December 8, 2020

**RE: GOOD HOPE HOSPITAL
New Building Expansion – Mental Health
Harnett County**

Plans relative to the above referenced project have been reviewed for general compliance with the 2018 North Carolina State Building Code with the following comments:

1. This review is on construction drawings dated September 11, 2020, reviewed by our office on December 8, 2020.
2. Please provide a written response to the review comments and submit revised signed, sealed plans as necessary.

G1.3

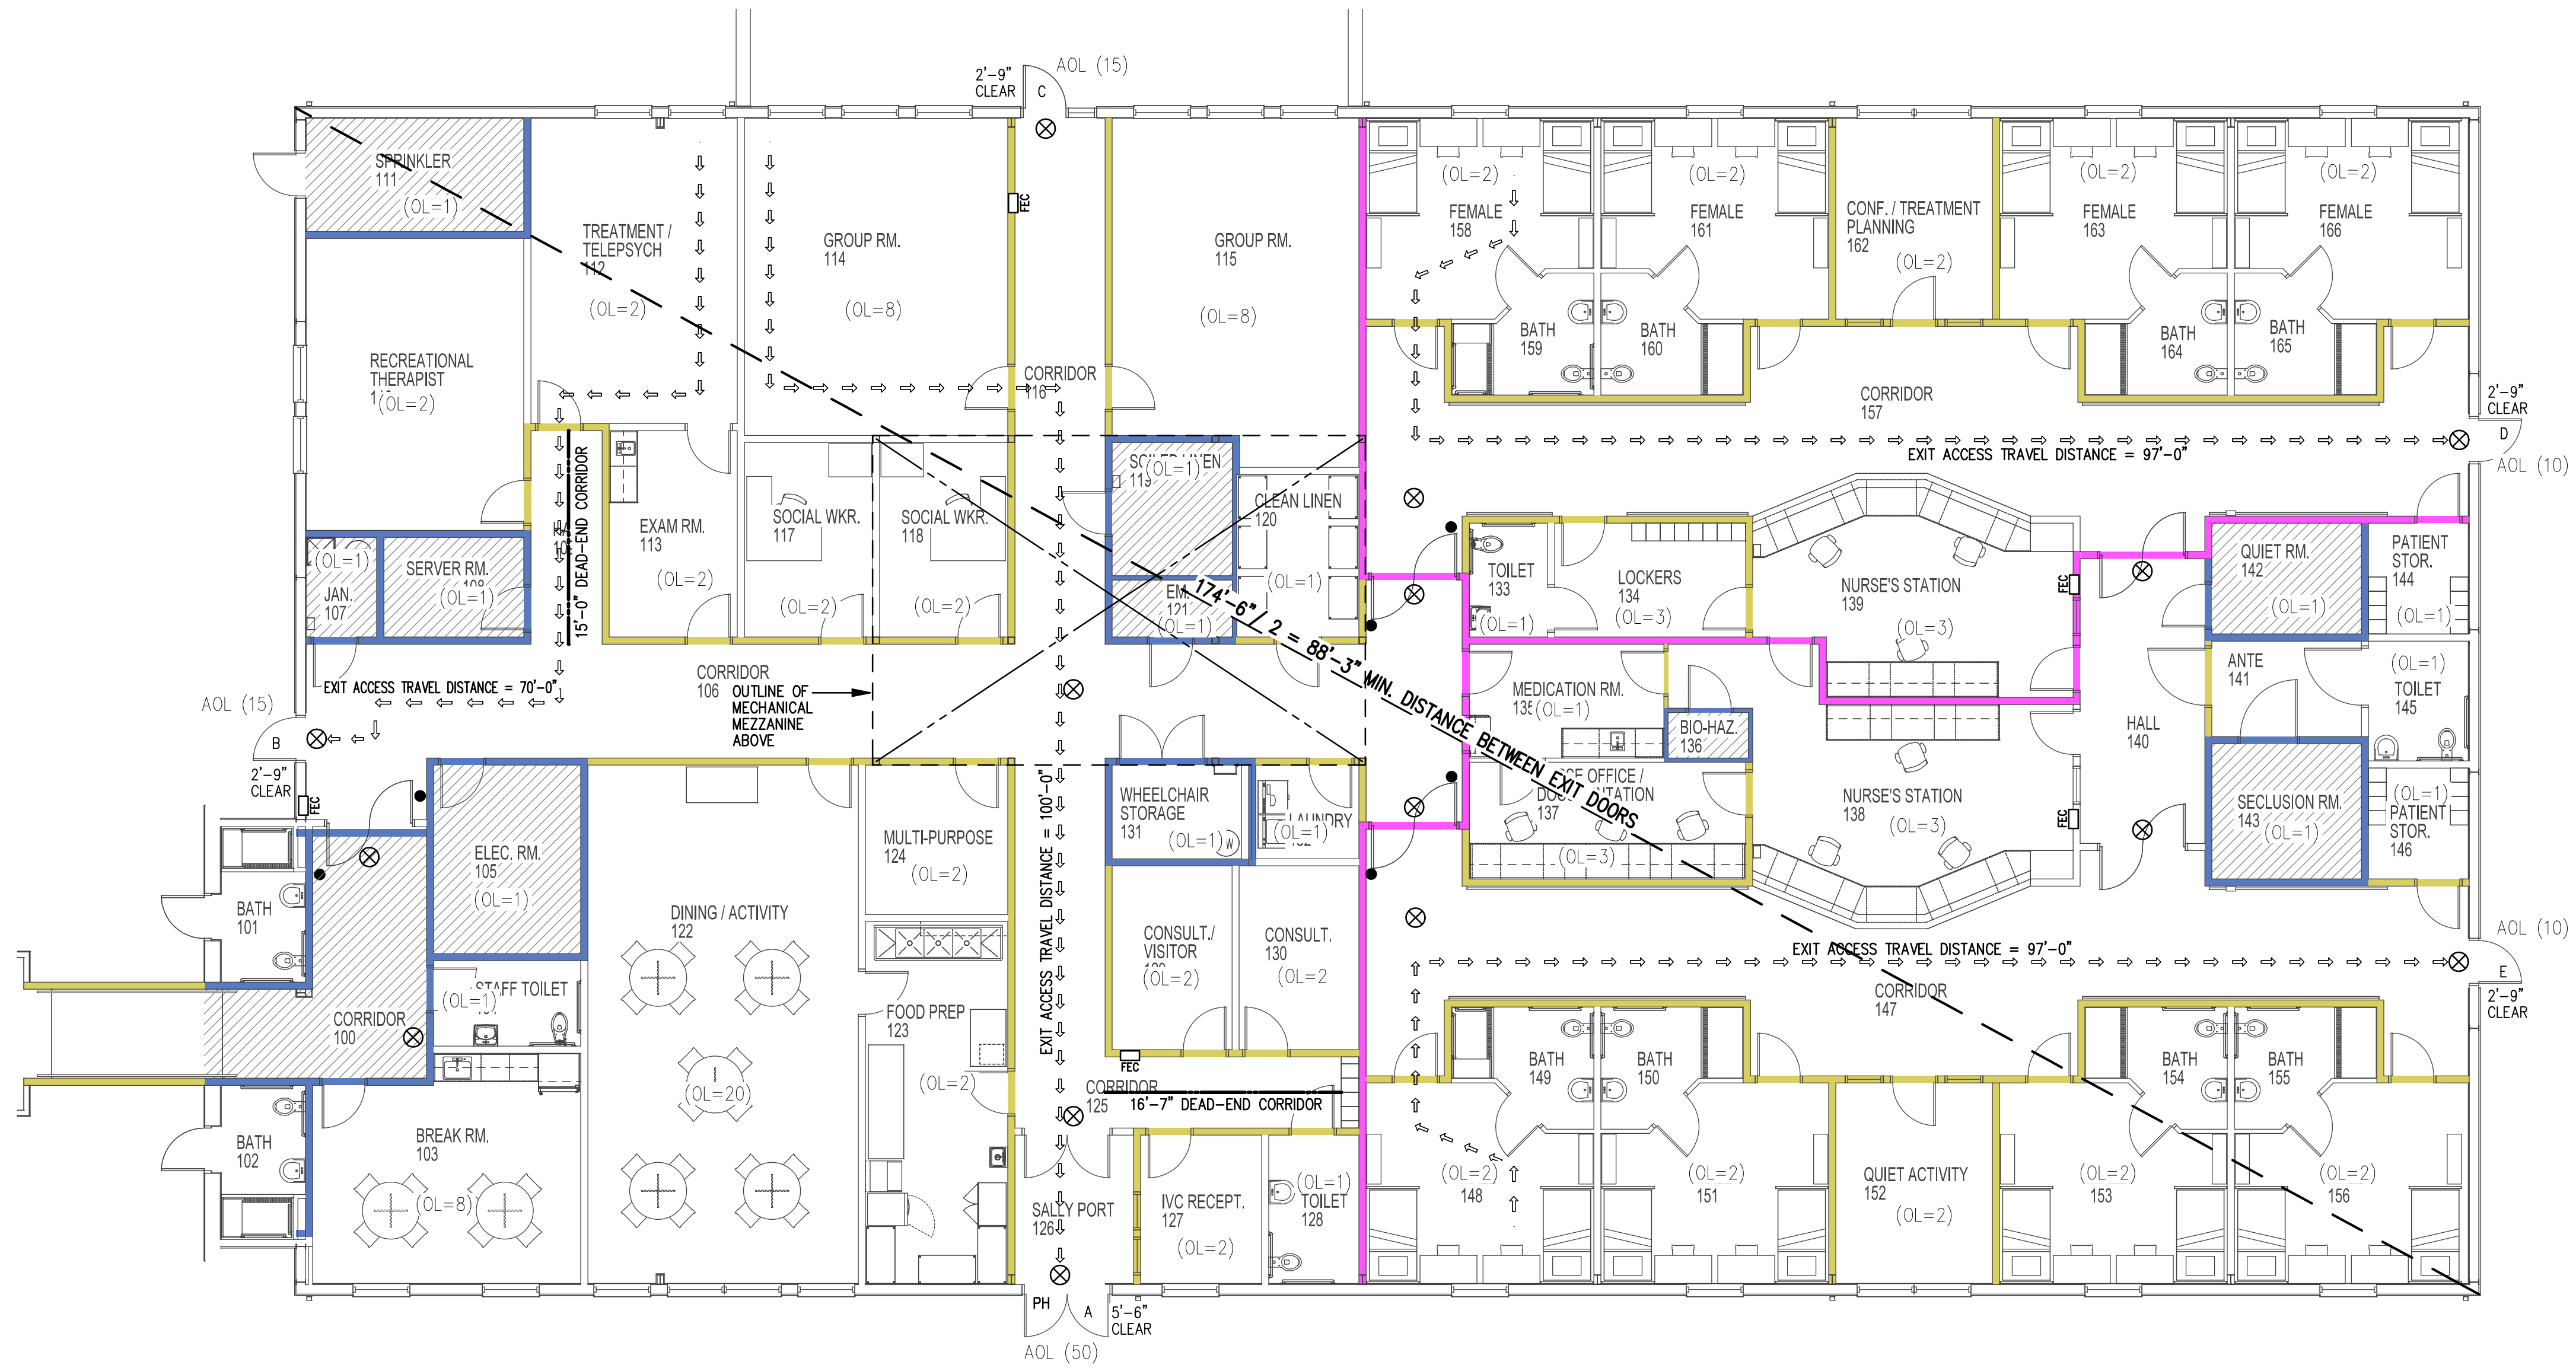
6. Structural design information is missing from both Building Code Summary sheets G1.1 through G1.3 and structural general notes and abbreviations on Sheet S1.0 are missing from plans; revise and resubmit. Show on plans.

10. Supply project specification.
11. Provide this office with signed and sealed prefab roof framing drawings and details when available.
12. Provide the construction type of the existing building on the Building Code Summary sheet.

1 MECHANICAL MEZZANINE PLAN
 SCALE: 1/8"=1'-0"

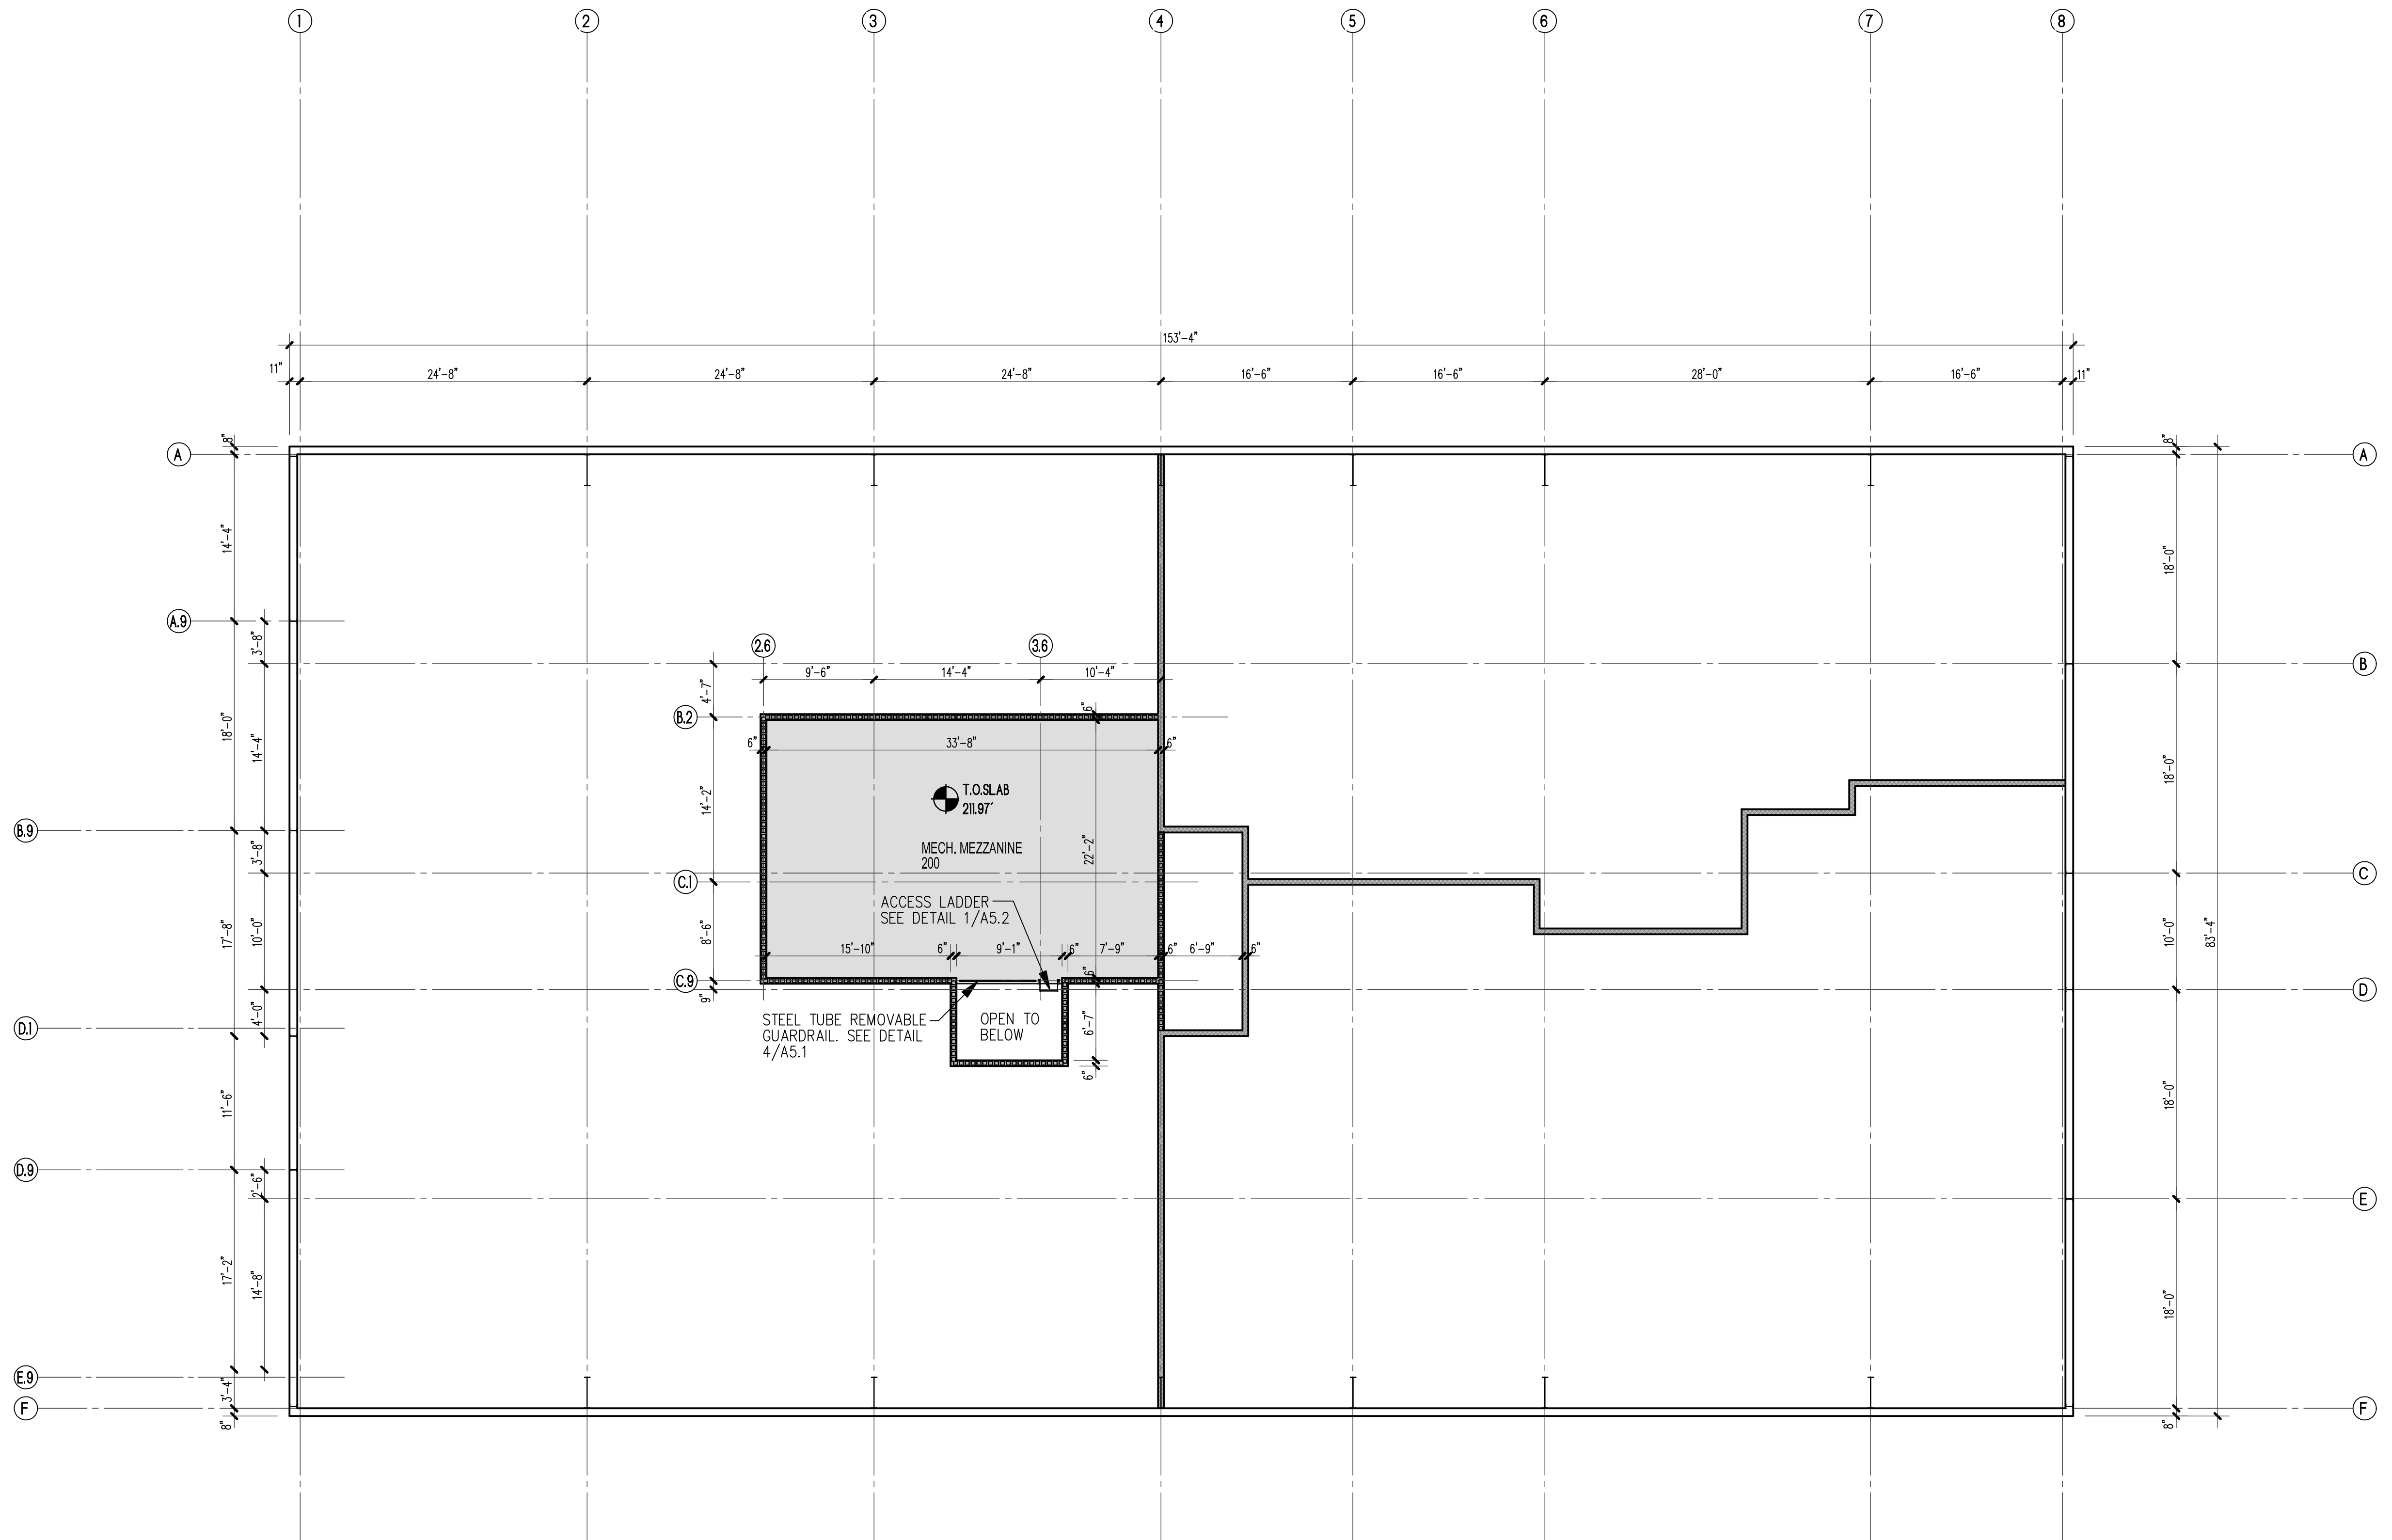
4. Verify and clarify automatic sprinkler system is installed in the concealed spaces (Mechanical Mezzanine) in accordance with Section 903.2.11.1 in both new addition and existing building. [2018 North Carolina Building Code Section 717.1 and 717.5]

STRUCTURAL GENERAL NOTES

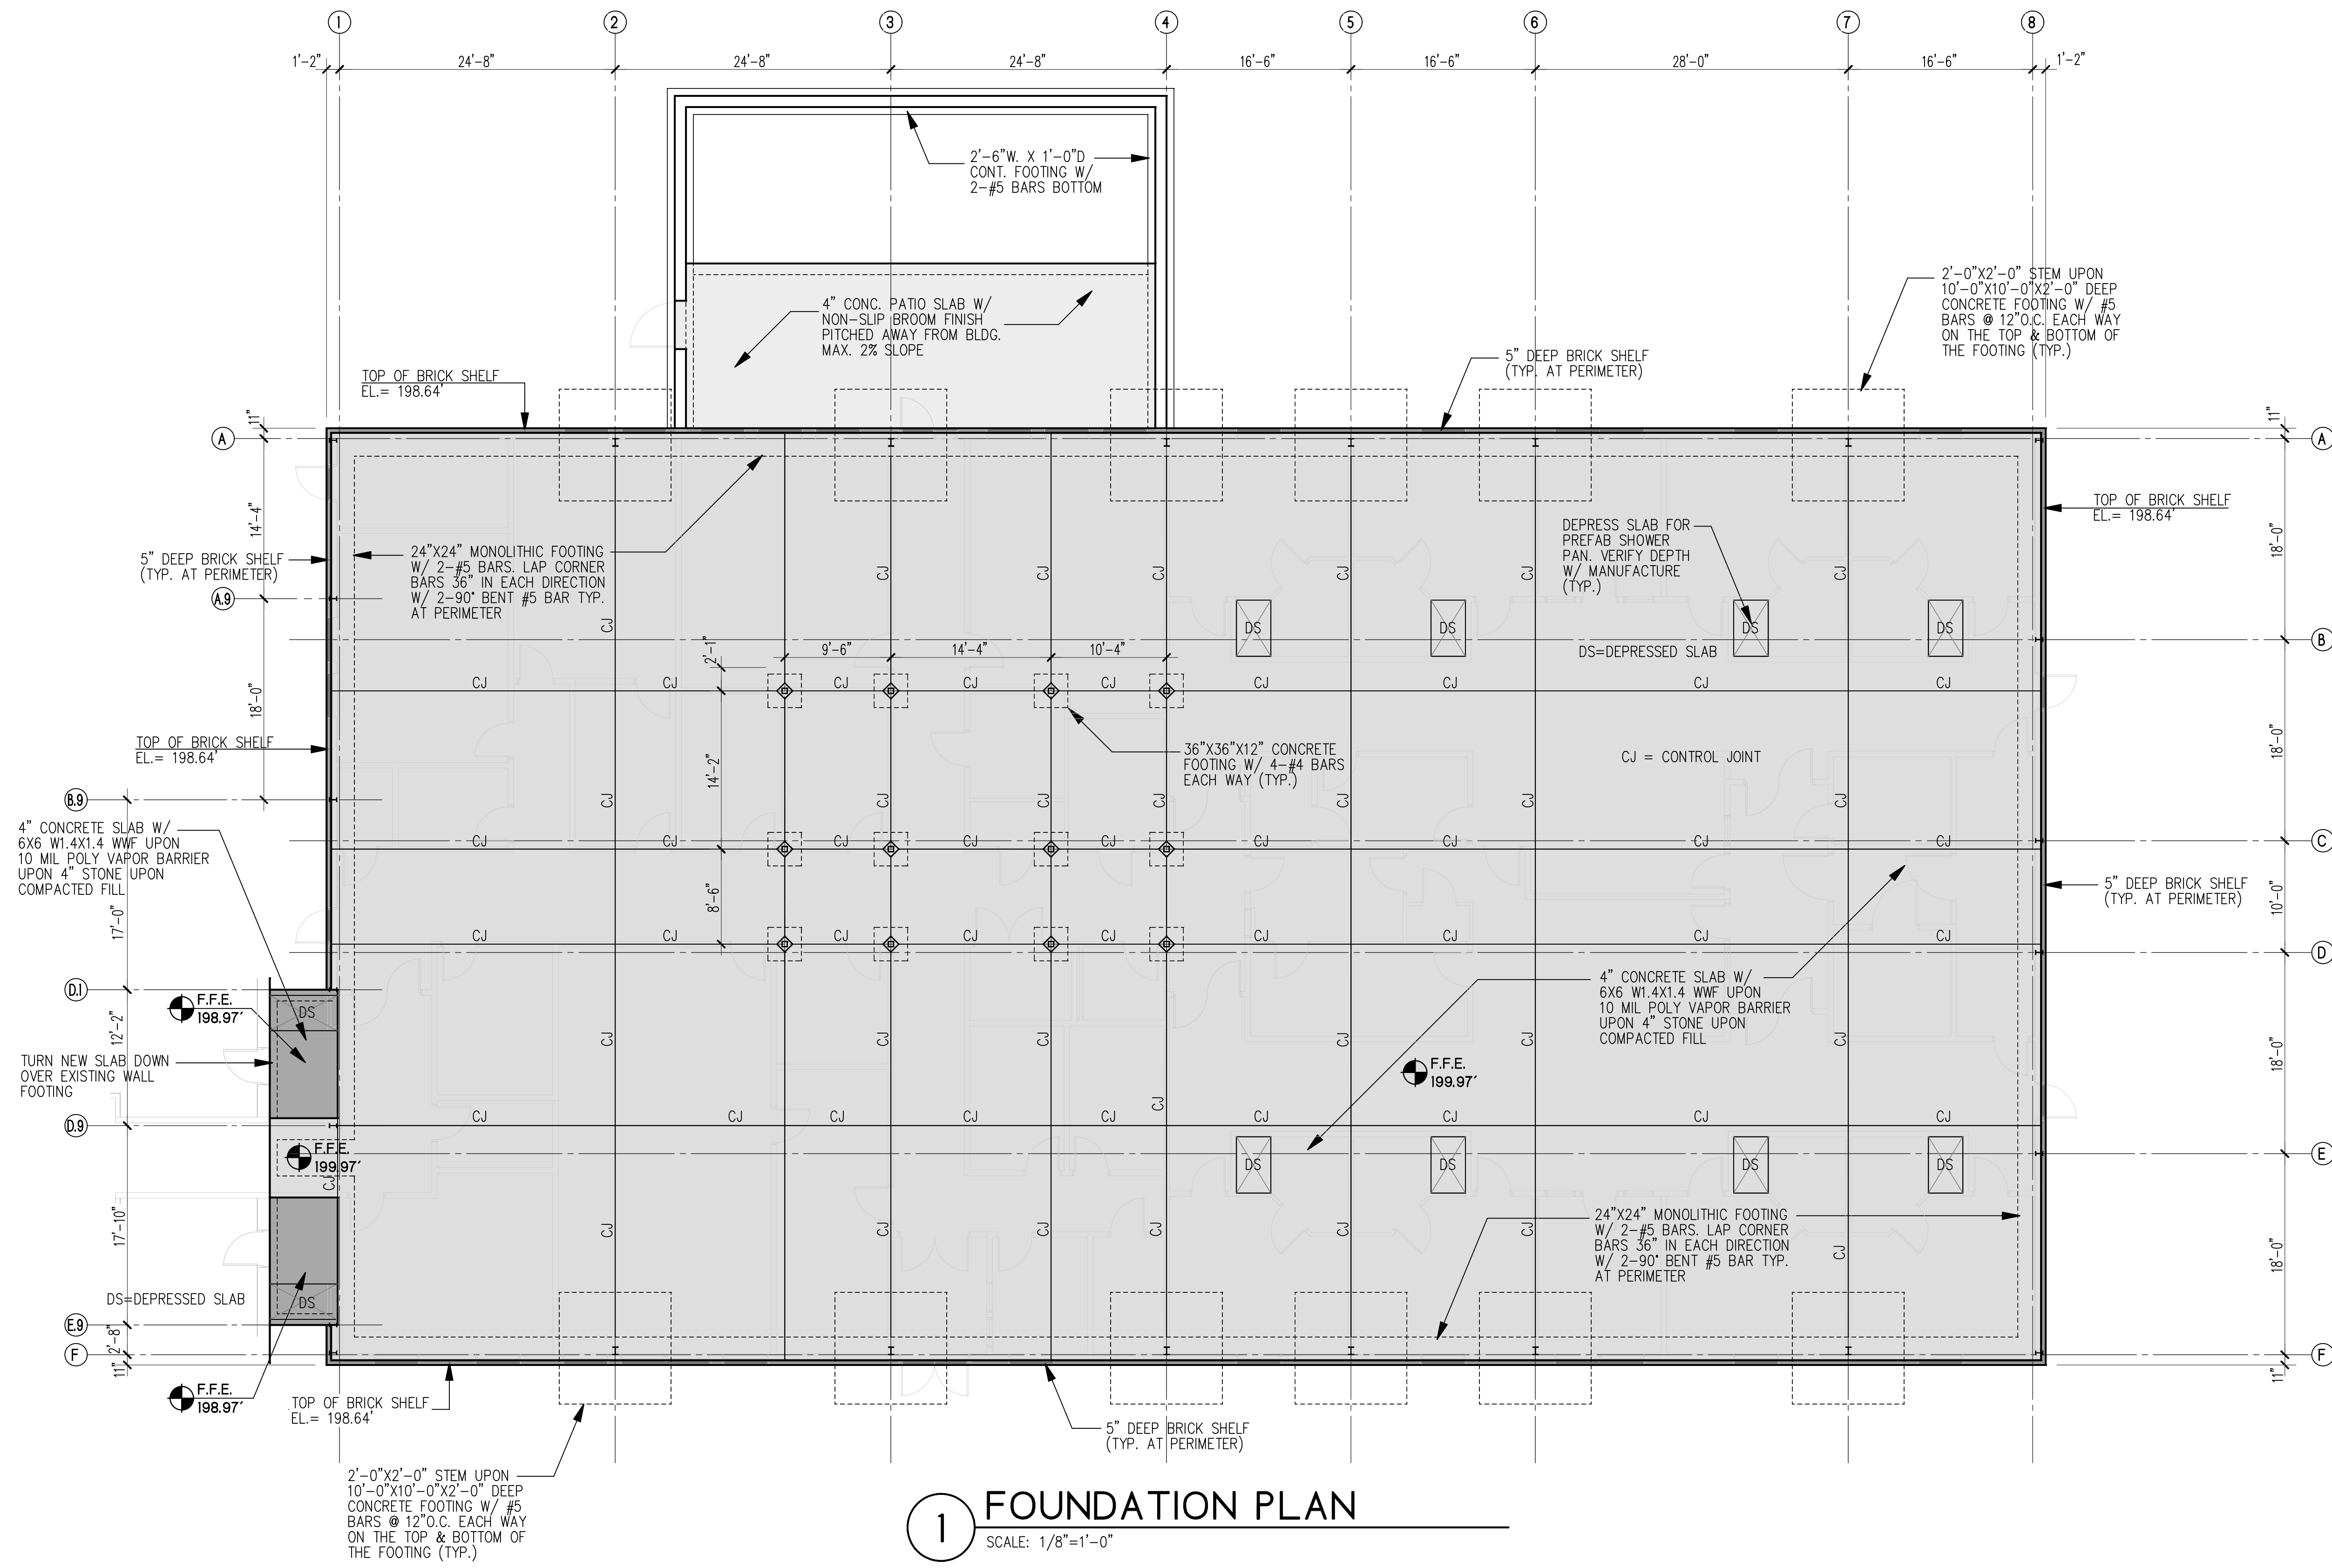
7. Provide project design loads on Structural sheet general notes and Building Code Summary sheet; both are blank of this information; revise and resubmit. Show on plans.
